To Protect and Promote the Health and the Environment of the People of Kittitas County

Dan Valoff, Staff Planner
Community Development Services
411 N Ruby Street, Suite 2
Ellensburg, WA 98926

RE: Alyssa Plat LP-08-00031 (Revised Comment Letter)

ALYSSA PLAT

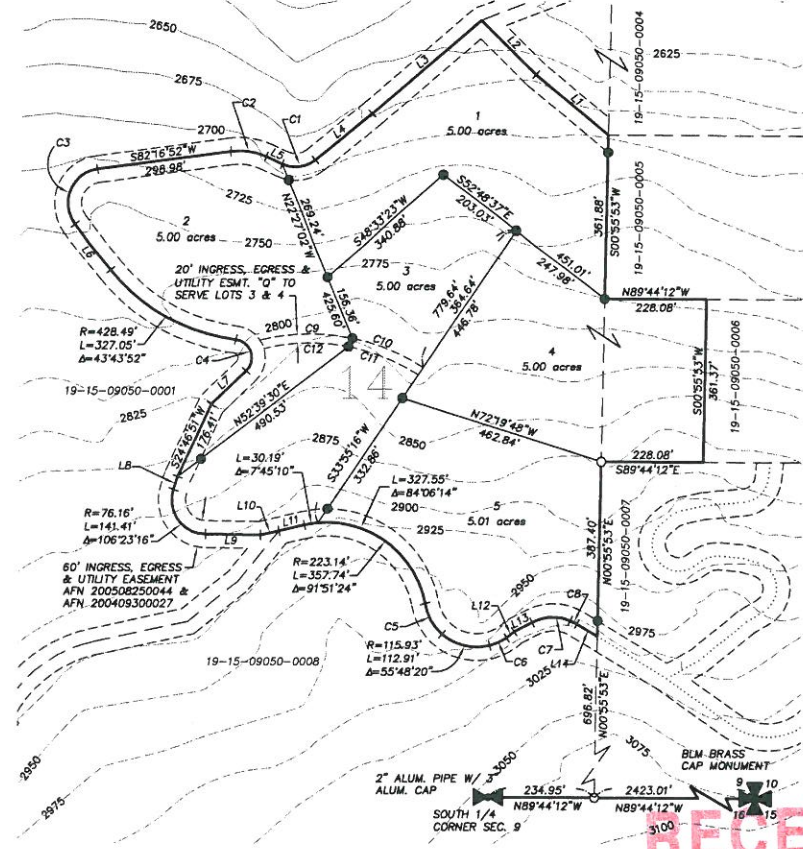
Thank you for the opportunity to comment on the Alyssa Plat, LP-08-00015. All residential well connections serving the proposed lots shall be required to have meters installed. Metering results shall be recorded in a manner consistent with Kittitas County and the State of Washington, Department of Ecology requirements. This requirement to meter only applies if you rely upon the RCW 90.44.050 exemption from permitting through ecology.

The final plat notes shall include the following two statements:

"The approval of this division of land includes no guarantee that there is a legal right to withdraw groundwater within the land division. The approval of this division of land provides no guarantee that use of water under the ground water exemption (RCW 90.44.050) for this plat or any portion thereof will not be subject to curtailment by the Department of Ecology or a court of law. "

"Metering will be required on all new residential well connections and metering results shall be recorded in a manner consistent with Kittitas County and Washington State Department of Ecology requirements."

The Public Health Department's recommendation shall state that Final approval be conditioned upon the developer/owner of the plat providing proof of water availability. Water availability can be provided through several different ways depending on the source of water proposed.

If individual wells are proposed for the parcels and there is an existing well located on the plat, a well log from the State of Washington, Department of Ecology and a passing bacteriological and nitrate test will meet the water availability requirement. If you have already put the wells in question to beneficial use, please complete the attached affidavit.

If there is not an existing well on the plat, then a **water availability report** with documentation and evidence to support the claim regarding adequate availability of groundwater for the proposed number of potable water wells must be submitted for review.

In either case a determination of water neutrality from Ecology will also be required to satisfy the water availability requirement. This requirement may be waived at the final approval stage if Ecology has modified the Upper Kittitas County Ground Water Rule in such a way that a determination is no longer required and the applicant has met all requirements of the modified rule.

Soil logs must be performed prior to the Public Health Department recommending preliminary approval of the plat. The Public Health Department's approval of the soil logs will meet the septic availability requirement for recommending preliminary plat approval.

At this time the application does not contain sufficient information to make a determination of adequate water availability or soil assessment to determine the land area is suitable for onsite sewage systems. The above mentioned items need to be submitted to the Public Health Department in order for the plat application to be recommended for approval.
